| Application number: 2026/91048 | |
| What is the application for?: | Erection of single storey front extension |
| Address of the site or building: | 6, Lee Court, Lee Street, Littletown, Liversedge, WF15 6QT |

PROPOSED

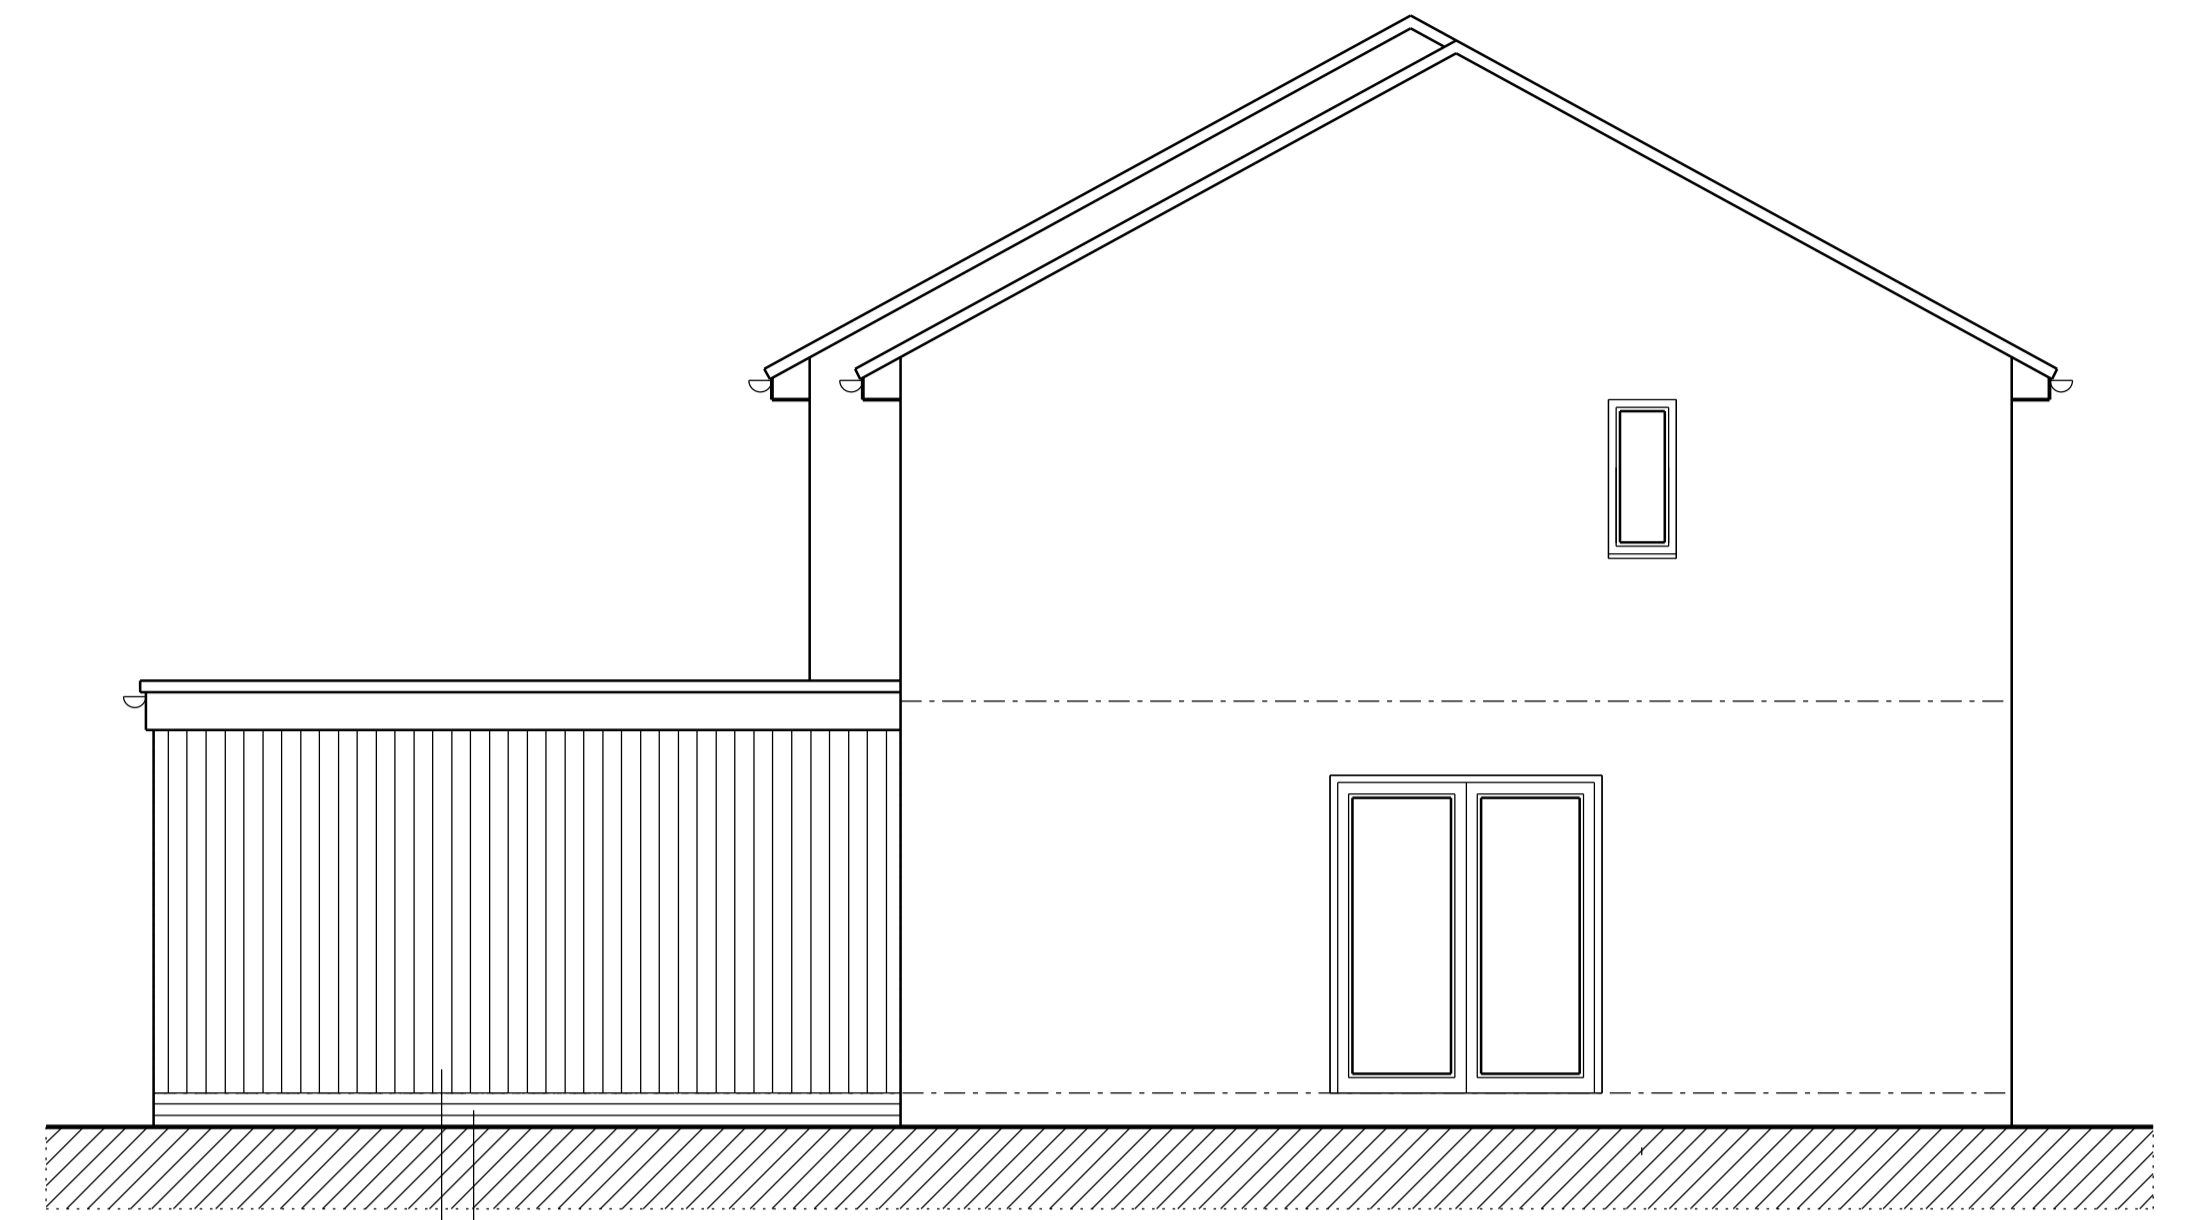
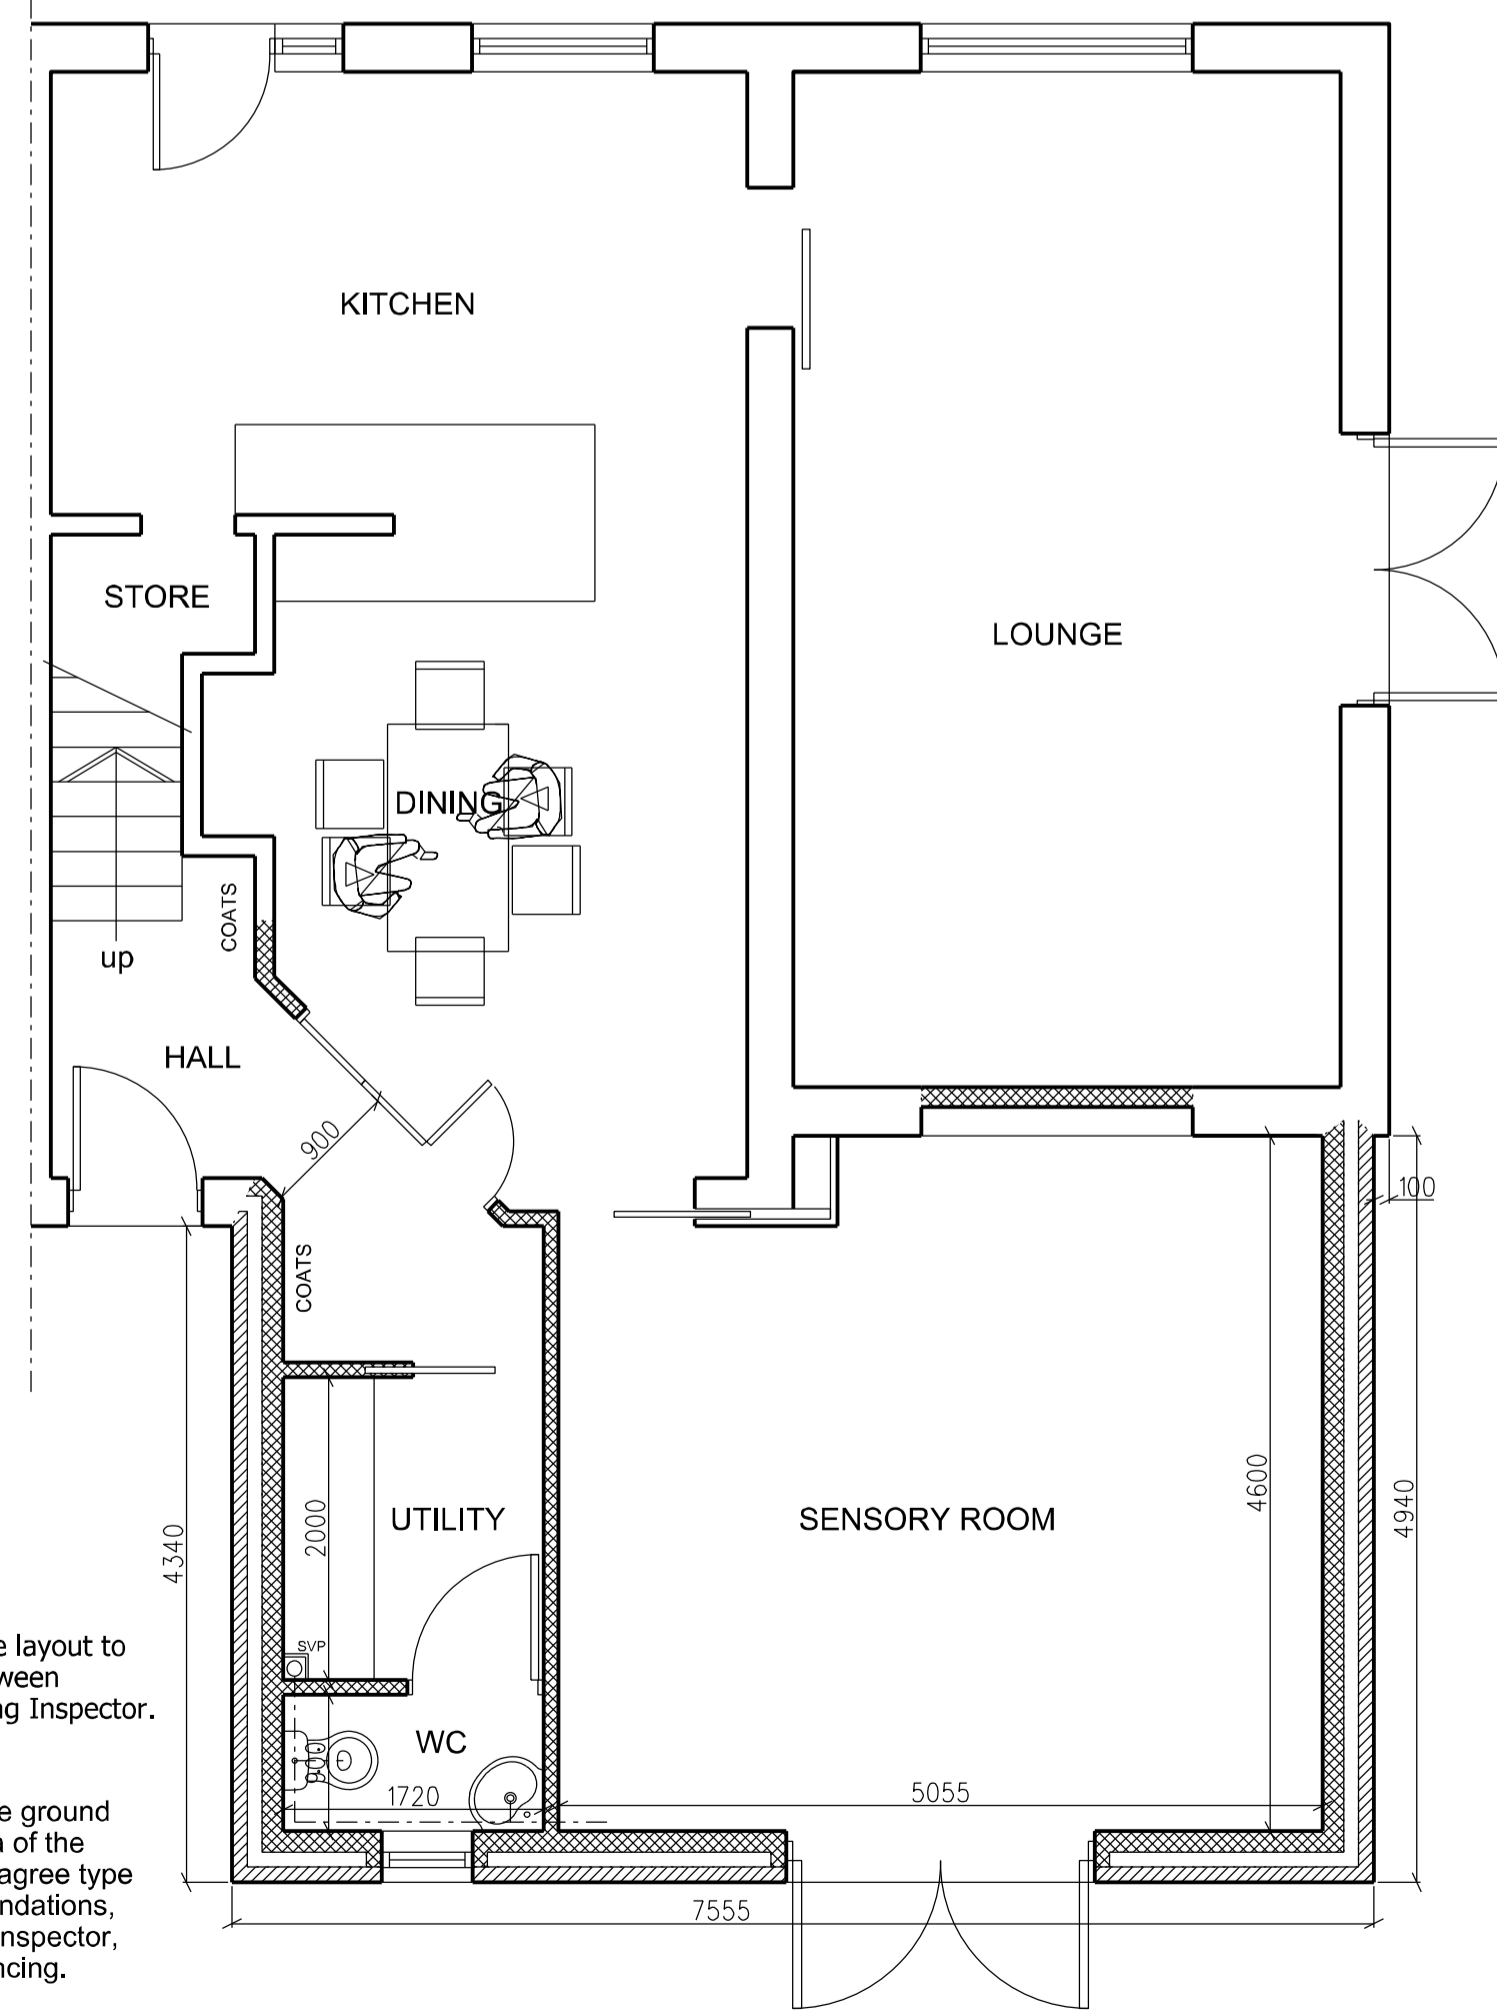
| <p>Lee court is open plan to the front of buildings the deeds indicate no building work to front of houses or fence erection. The finish is not compatible to existing dwellings, it would have to be imitation stone to blend in. the size is excessive and protrude too far from existing line of building, it would look like a giant shed bolted onto the front of house. Extension would have major impact on the appearance of court. there has been a large building erection in the back garden in the past months and the house has in in past been extended to the side. existing roof drainage from all the houses runs directly under the proposed extension. The structure of the tarmac in the drive does not allow for heavy wagons to transverse and damage in the past has occurred, therefore materials would have to be delivered to the far side via Stanley lane.</p> | |
